Memorandum

To: City of Mercer Island
From: KPG Psomas
Date: 3/19/2024
Re: Review of Transportation Concurrency Application and Transportation Impact Analysis Scope (dated 2/6/2024) for a Private School located on the Herzl (HNT) property (TCC24-004-sub1)

The City of Mercer Island requested KPG Psomas to complete a peer review of the Transportation Concurrency Application and Transportation Impact Analysis (TIA) Scope dated February 6, 2024 for a private school and office development (TCC24-004-sub1) located on the Herzl property at 3700 East Mercer Way. The proposed development includes a 14,051 square foot private school that will enroll up to 150 students in the PK-8th grade levels and 12,300 square feet of office space.

# School Trip Distribution and Assignment

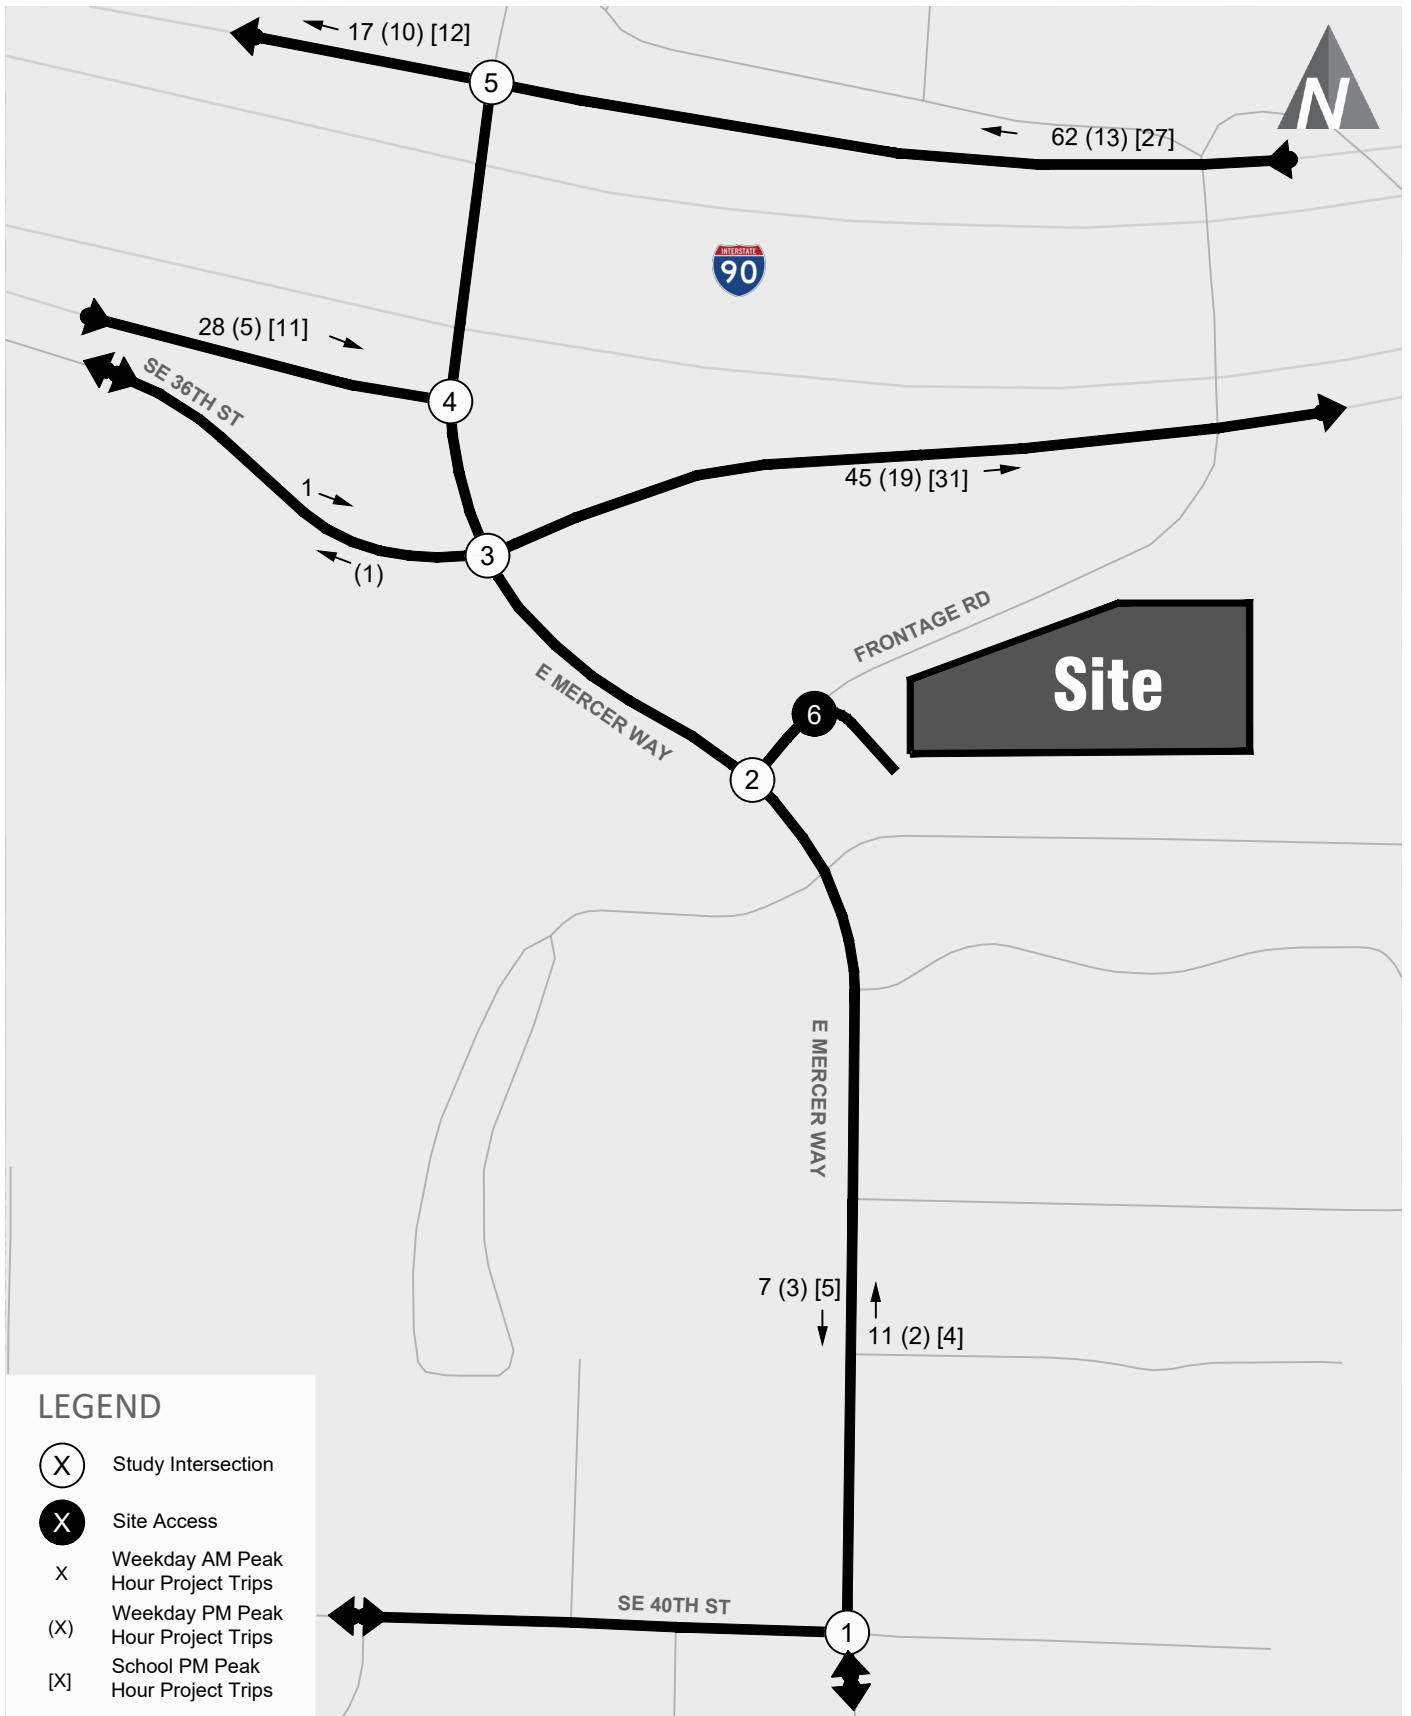
Project Trip Distribution: Table 2 of the Transportation Impact Analysis shows trip distribution percentages for school trips and office trips. The proposed trip distribution percentages are acceptable. The applicant should revise the trip assignment numbers based on the updated trip generation numbers.
